PLANNING DEPARTMENT – Development & Building Services

RE: **Drainage Management Plan (DMP) Update** – incl. Bosque School Area Ponds
SE Corner of Coors & Montañó NW P.E. Stamp: 10/31/12 File # **E12-D015**

DMP Update - Bosque School Area

D OVERFLOW AREA ENLARGED GRADING DETAIL
SCALE: 1" = 30'

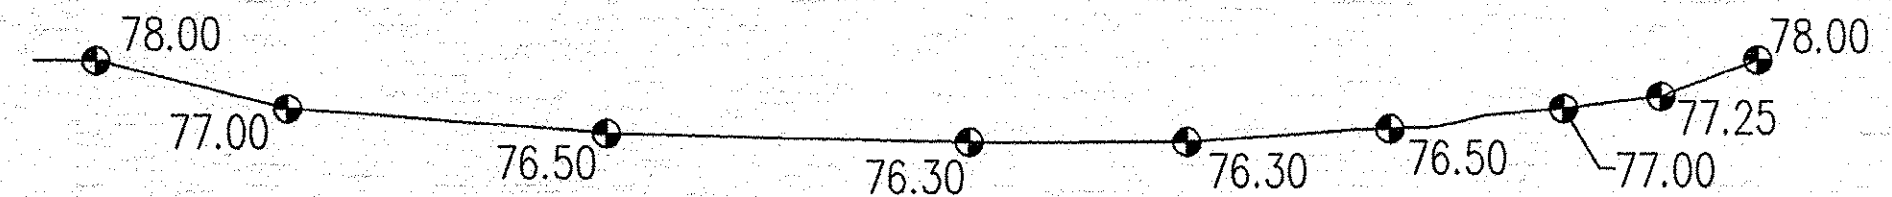
12. "Pond B" limits and volume must also be confirmed and certified. If any regrading is needed, your submittal should also request Grading Permit approval, with Engineer's Certification following completion of that grading. Clearly show and label where the overflow point is located, along the Riverside Drain, with an elevation that will avert flooding of the school structures.

B WEIR SECTION B-B
N.T.S.

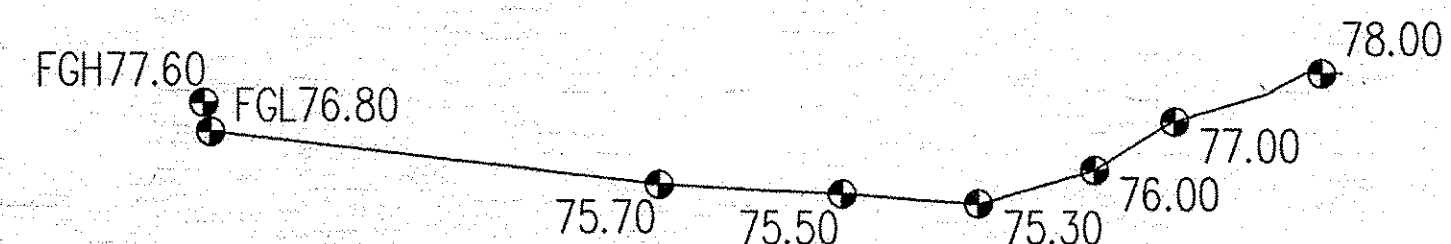
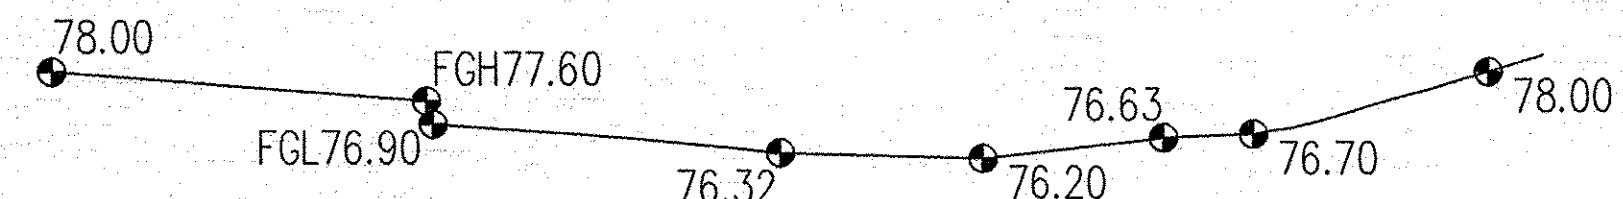
11. Spillway concerns include:
 - a. Provide horizontal control on the layout and cross sections.
 - b. Provide build notes, cross sections and/or details to clarify the features of the proposed spillway.

- c. The spillway and water weir sections conflict with the Modular Building pad and ADA ramp. When Weir details are presented, clarify Section B, which appears to intersect the footprint for the Modular Classrooms, which show F.F. Elev. 80.33 ±.

E POND 'A' SECTION D-D
N.T.S.

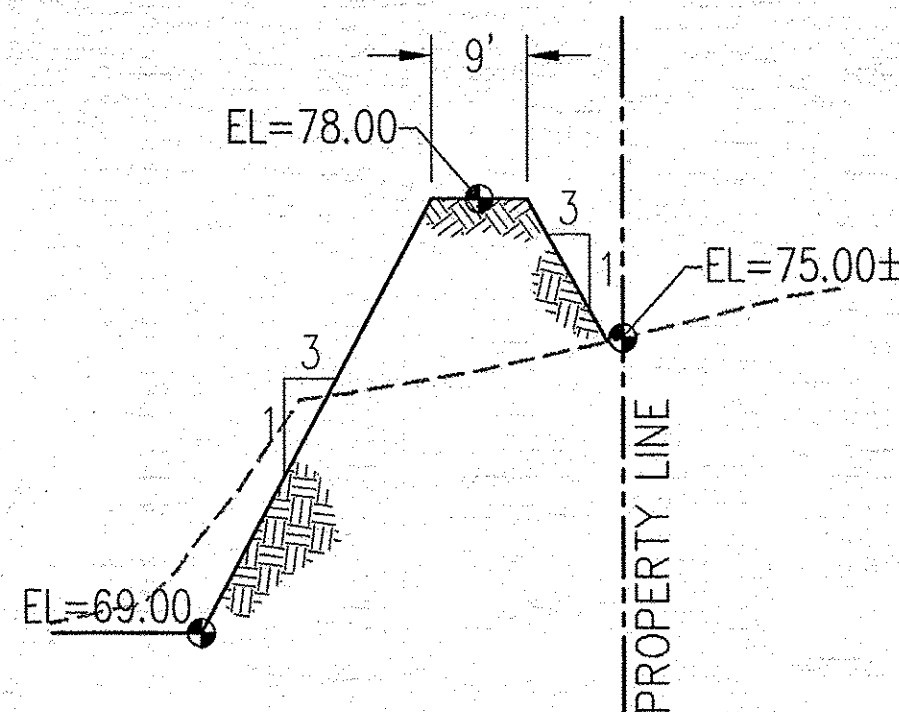
10. We require a separate, larger scale Grading Plan for any proposed grading at Pond A (or Pond B) and the spillway to Pond B. Section E-E should include a water surface elevation, representative of the standing water observed within the pond. Spring 2012 photos show that level to be roughly 2 feet above the invert of the 60" inlet line at the south end of Pond A. Pond volume calculations cannot include any capacity below the observed, standing water surface.

REVISIONS	
△	
△	
△	
DRAWN BY BHW	
REVIEWED BY JLM	
DATE 08/29/2012	
PROJECT NO. 20120222	
DRAWING NAME	
FINAL DRAINAGE PLAN

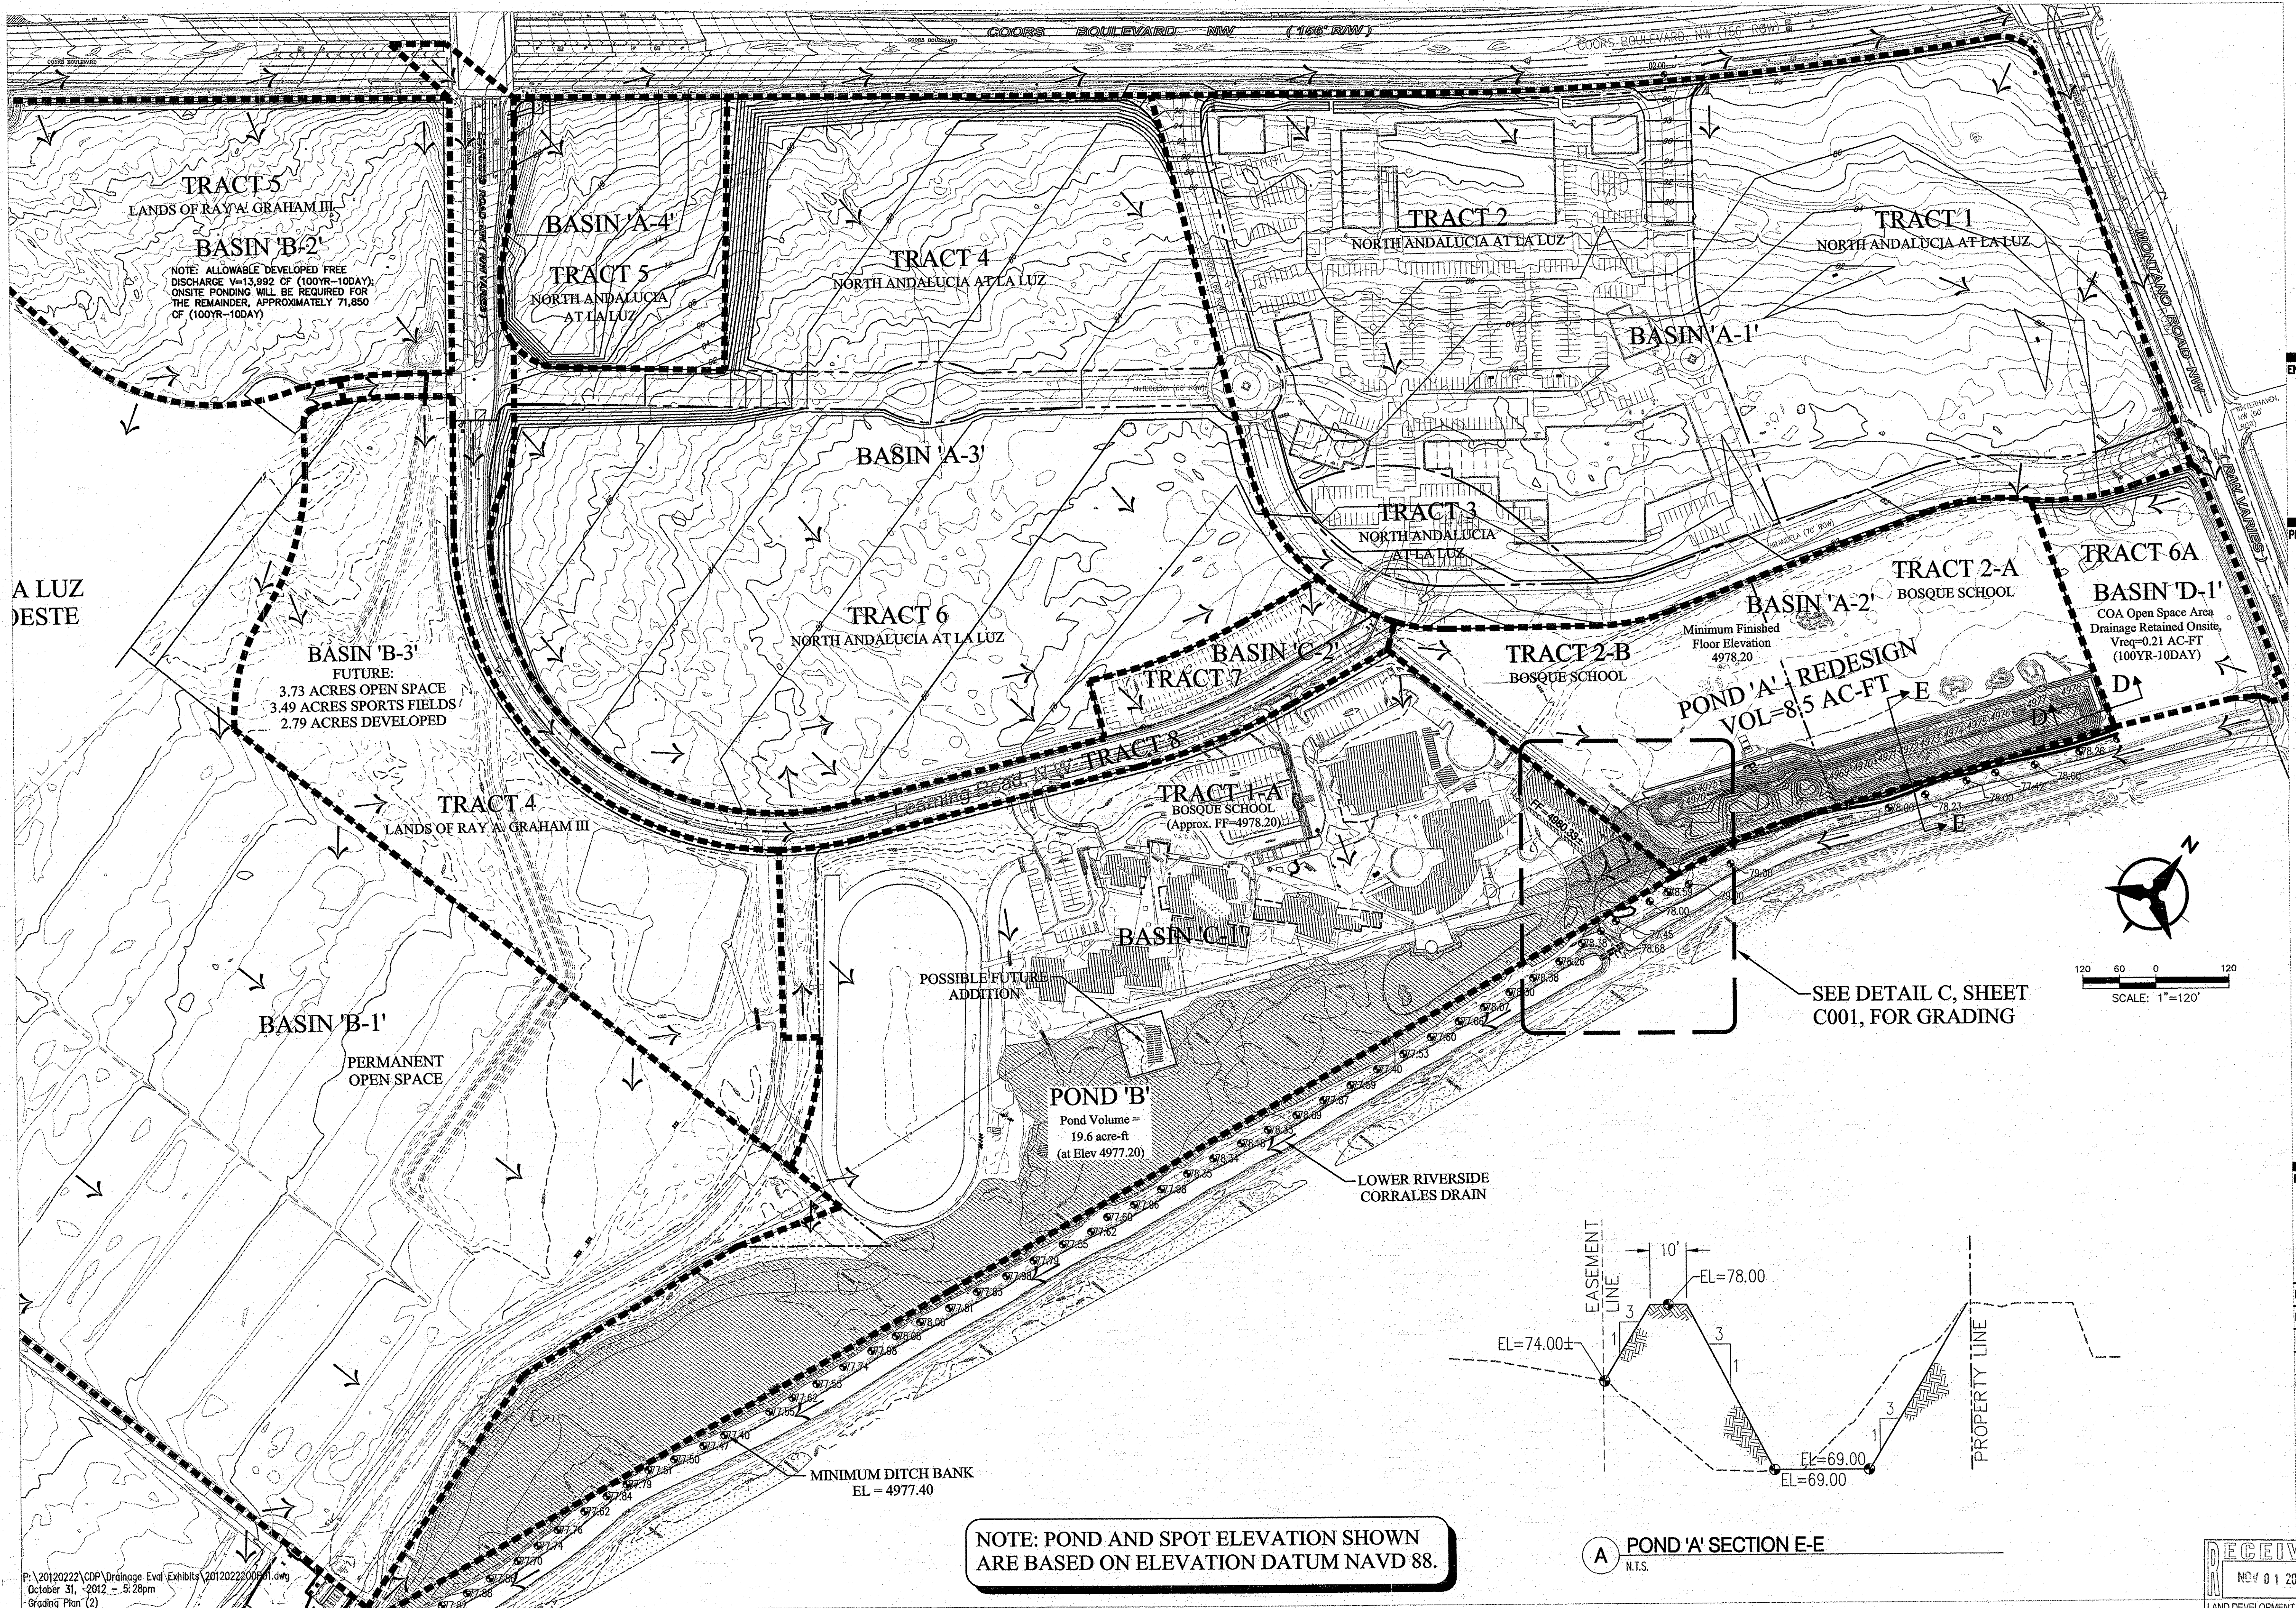
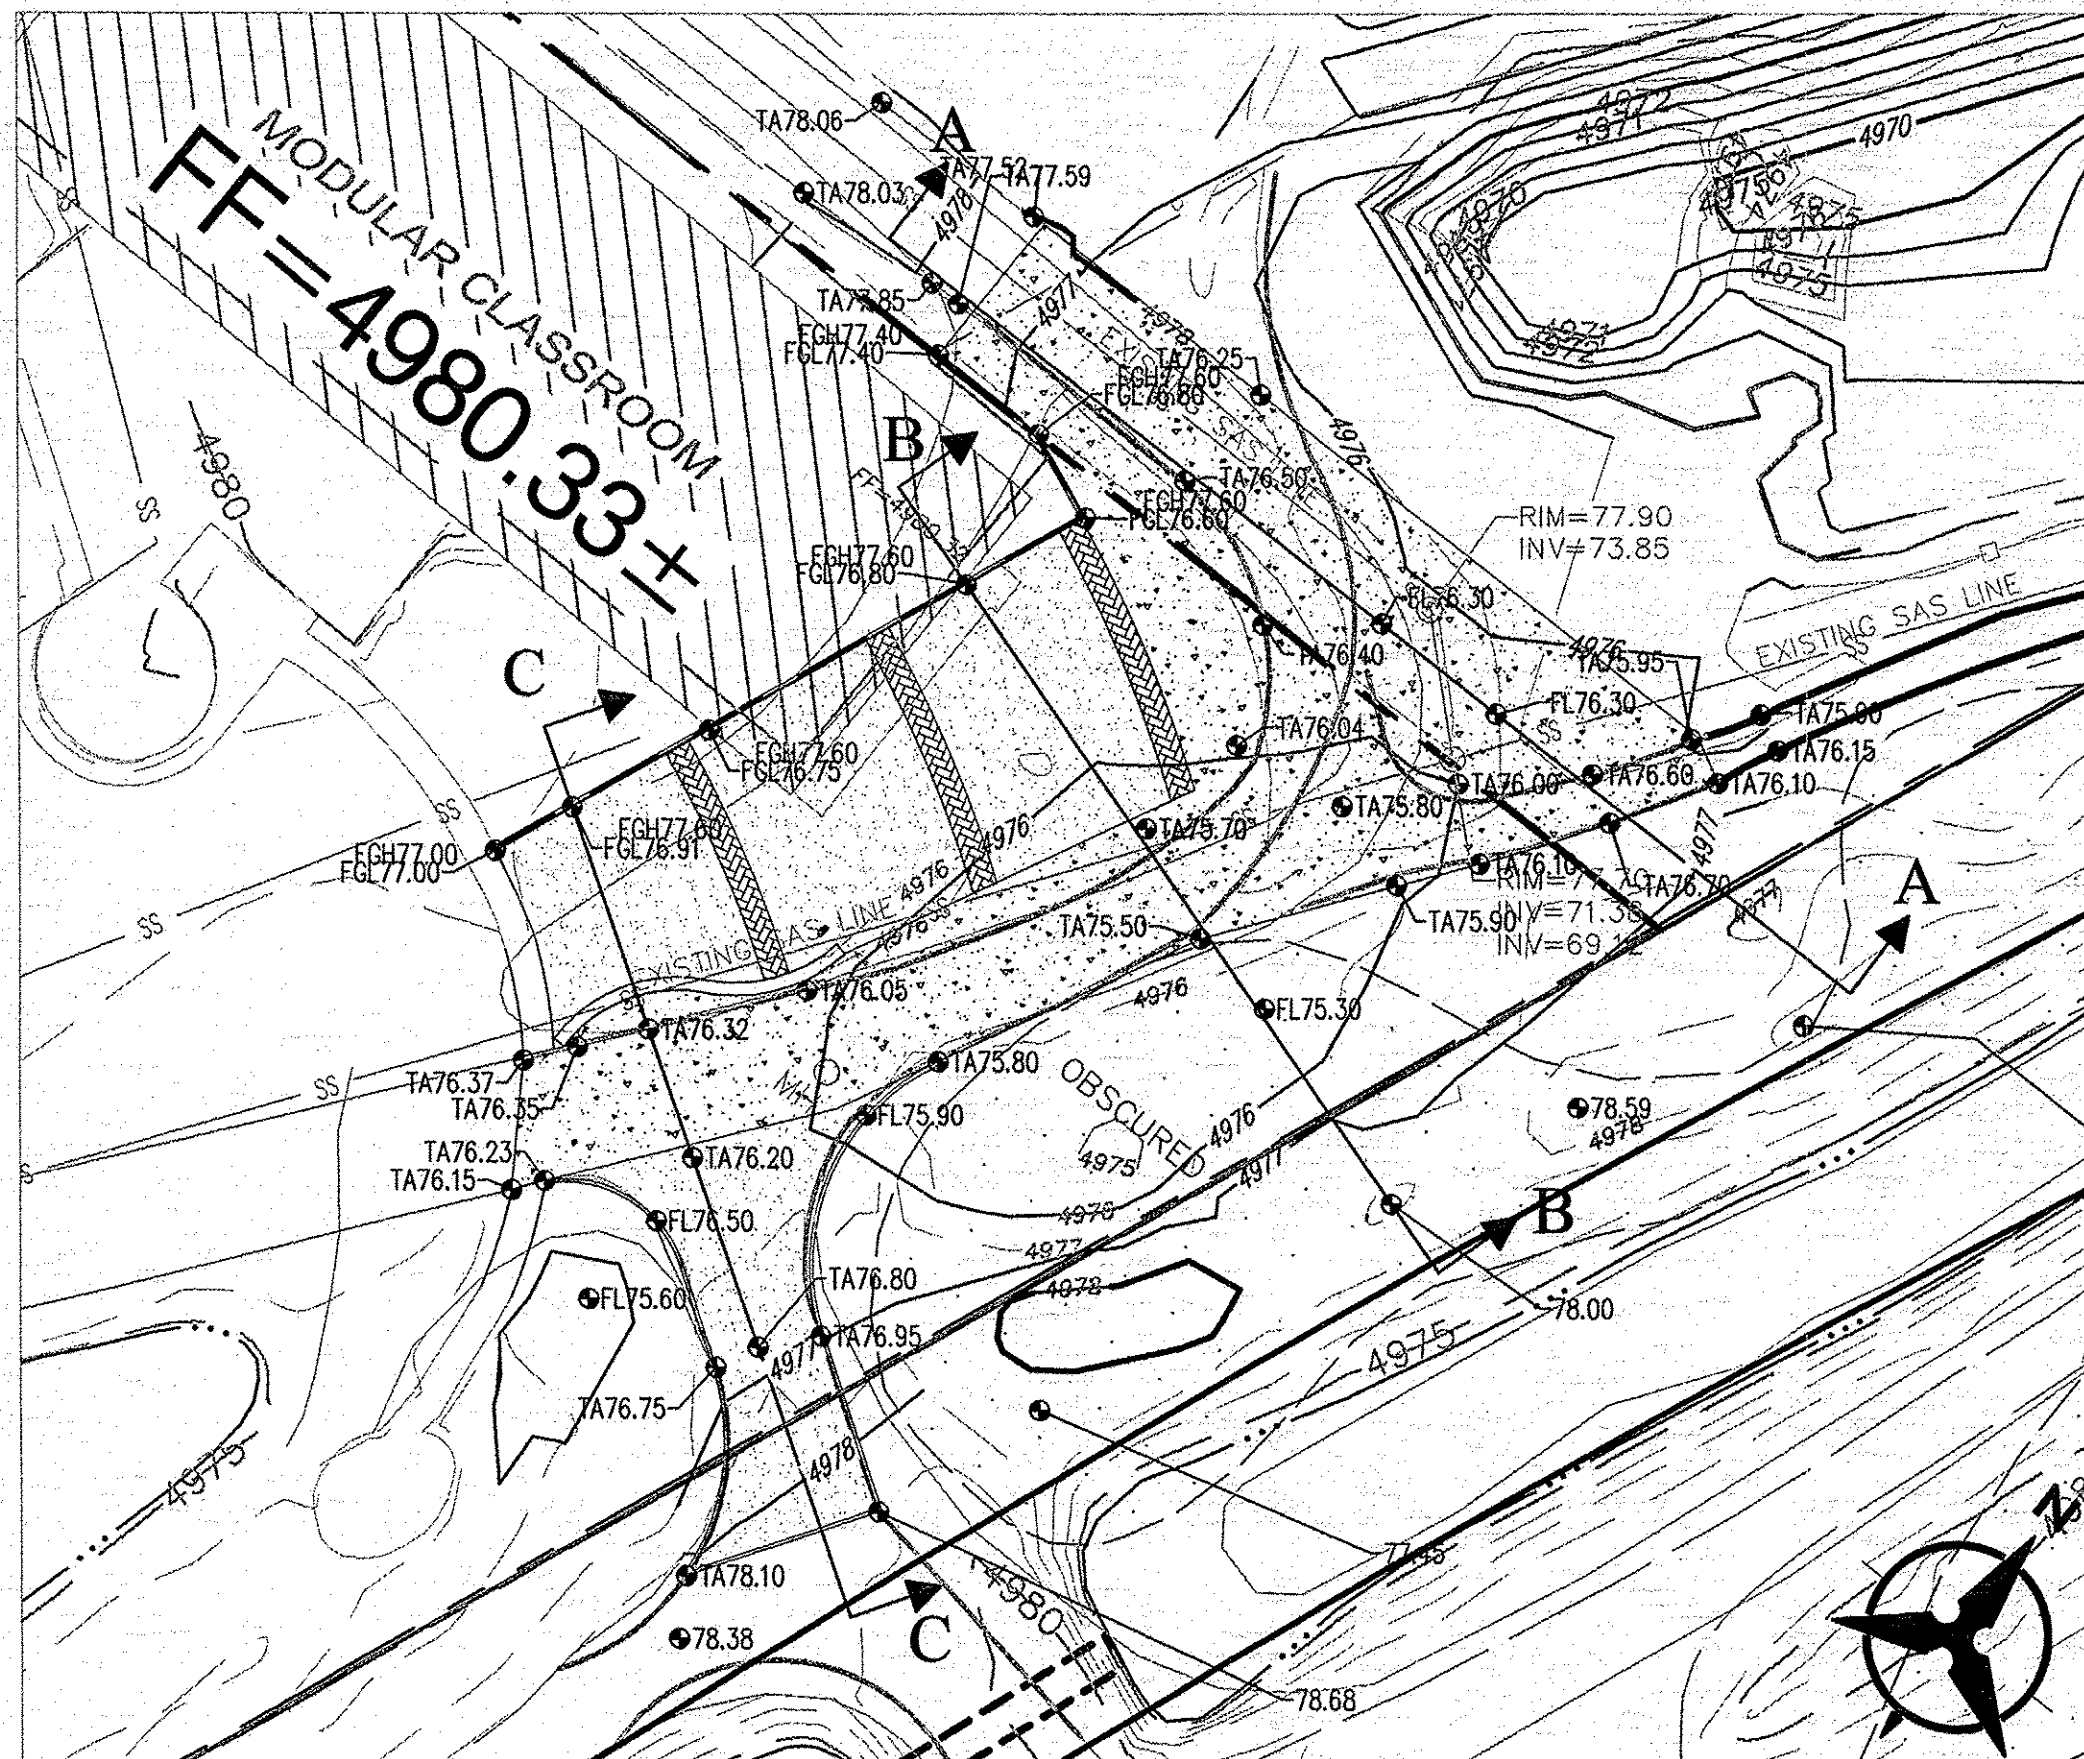
2. The proposal to limit Basin B-2 to undeveloped rates is not acceptable. Reductions in runoff to meet pond volume limitations must be shared across the analysis area.

7. The 2006 DMP, prepared by BHI, shows a Min. Finished Floor elevation of 75.50 on Tract 2 (now Tracts 2A & 2B), North Andalucía at La Luz, underlying "Pond A." This plan proposes a water surface of 77.2. Explain this significant revision.

8. "Pond A" limits and volume must be confirmed and certified. If regrading is needed, your submittal should also request Grading Permit approval, with an Engineer's Certification following completion of that grading.

9. In a June 11, 2012 letter from the Water Utility Authority (owners of Tract 2A, North Andalucía at La Luz) to the Environmental Planning Commission, Mark Sanchez, Executive Director, indicated that the "Water Authority will not consider or allow any modifications to these ponds." Your submittal proposes regrading of Pond A, effectively creating a dam at the drainage easement boundary on Tract 2A, with a crest only 0.2 feet below the minimum Finish Floor elevation on the tract. This will prohibit runoff from Tract 2A to the pond. Also, the grading apparently allows Pond A water (Elev. 4977.2) to flow around the south end of the proposed dike and flood Tracts 2B and 2A. How can this plan be implemented without land owner concurrence?

13. There is a peninsula within Pond B labeled "Possible Future Addition." Is that area and volume excluded from Pond B capacity? Pond B calculations should also acknowledge and identify any water table exposure, or standing water from Riverside Drain seepage within the pond section.

14. The Drainage Study table in this submittal made reference to Basins B-1 and C-1 runoff as "Taken from..." drainage reports by Bordenave Designs and Chavez-Grievies, respectively. We do not have those reports on file. Please provide copies for references, or generate your own runoff calculations for the subject areas.

- b. Include a Bench mark for reference on this DMP, and on any survey documentation submitted.
 - c. The drainage plan must show all Basins included in the analysis area, including all of the Lands of Ray Graham/La Luz tracts that discharge to the ponds. Hence, the limits of the basin layout plan must be extended to the south & west.

- d. The tabular presentation of Pond volumes and runoff calculations is very helpful. Please summarize basin data by tract, and provide Area and Runoff totals at the bottom of the table. Supplementary calculations and tables may be necessary to clearly document ponding and freeboard capacity.

- e. For clarity, separate the DMP drainage analysis from the design information for the proposed Spillway between pond A and pond B.
